From: Matthew Chadwick
Sent: 03 August 2020 10:52
To: DC Support
Subject: FW: 20/01747/F - Land South Side Of, Widnell Lane, Piddington

From: Tim Screen <Tim.Screen@Cherwell-DC.gov.uk>
Sent: 31 July 2020 16:20
To: Matthew Chadwick <Matthew.Chadwick@Cherwell-DC.gov.uk>
Subject: 20/01747/F - Land South Side Of, Widnell Lane, Piddington

# Proposed Block Plan

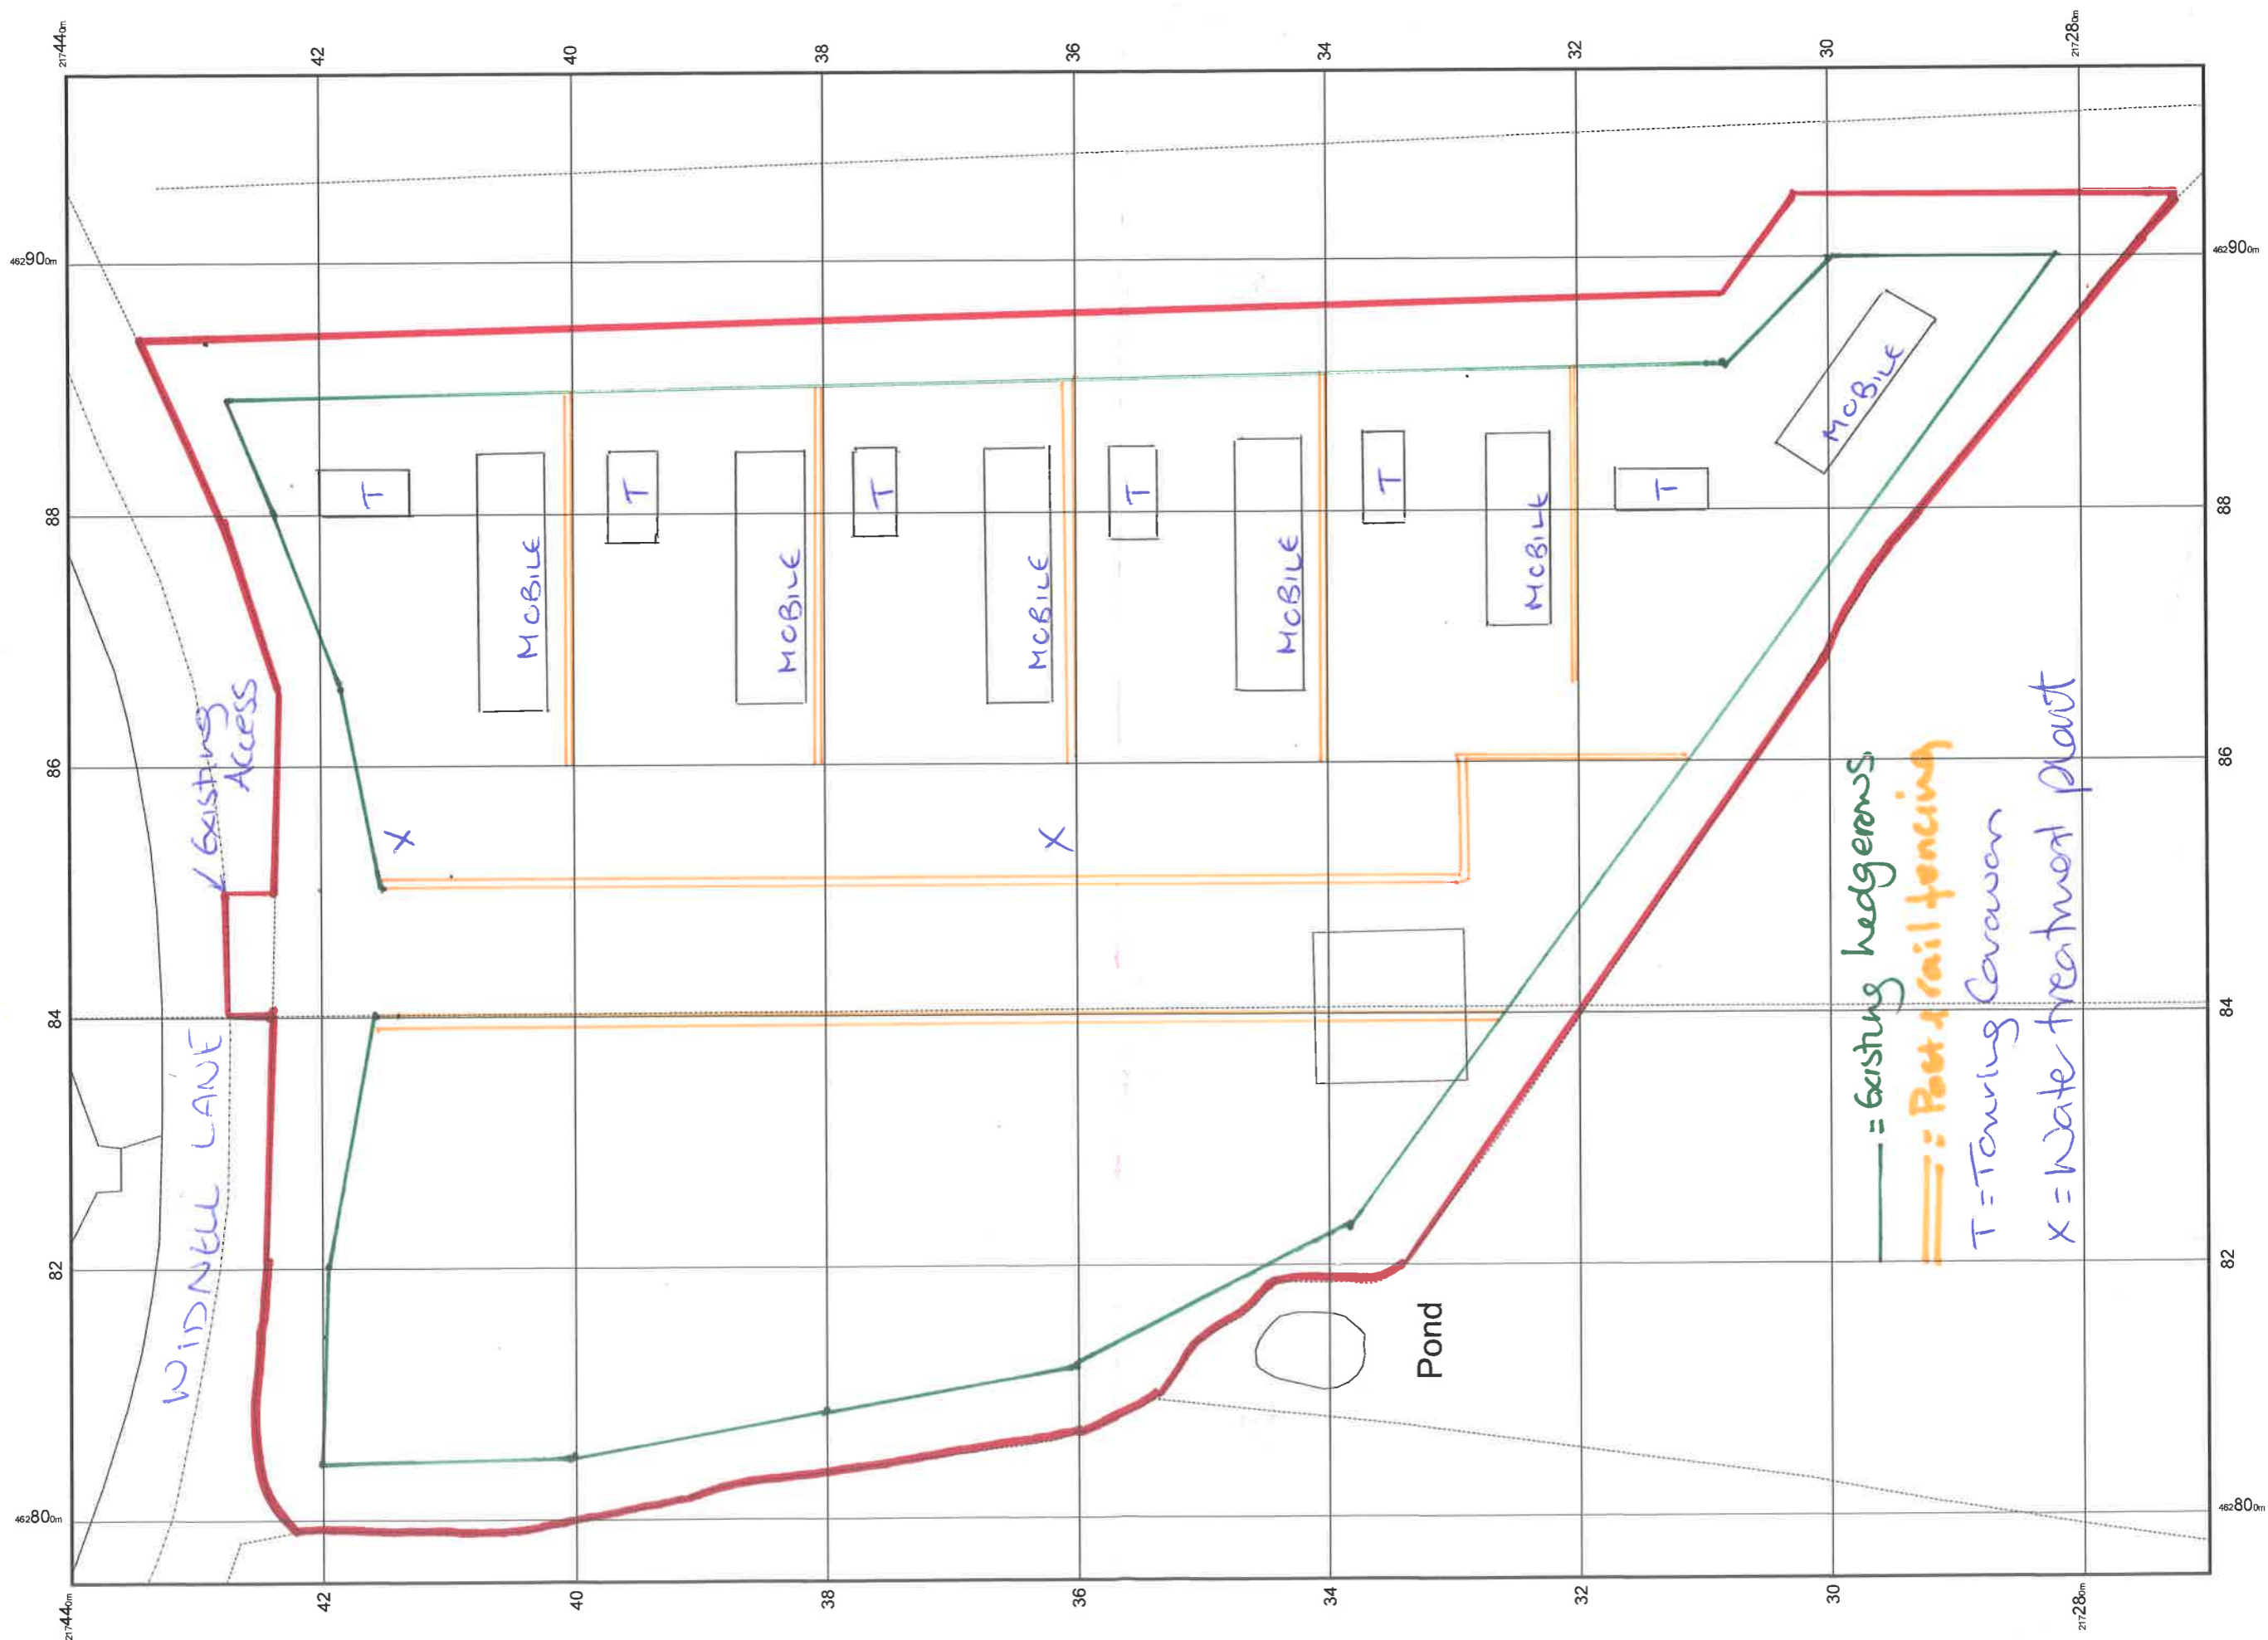
In order to minimise visual and landscape harm the existing site boundary trees and hedgerows are to be retained and maintained at their mature heights (a minim of 3 m for the hedgerows). There is no hedgerow on the eastern boundary. I recommend the planting of a hedgerow to the entire eastern site boundary with individual Oak and Field Maple trees. The hedgerow to be set out in a double staggered row, 50 cm between rows and 45 cm between each plant. The plants are to be supplied as 80 -100 cm, and planted with spiral rabbit guards with cane supports. A mulch matt is required for each plant to conserve ground moisture and restrict competitive weeds. The hedgerow material is to be 40% native Blackthorn and 60% native Hawthorn. The native hedgerow and trees must be maintained to ensure this landscape feature is established. Hand weeding, watering in periods of dry weather, and replacement planting in the planting season (Oct – Mar) where there are deaths and damage within the planting.
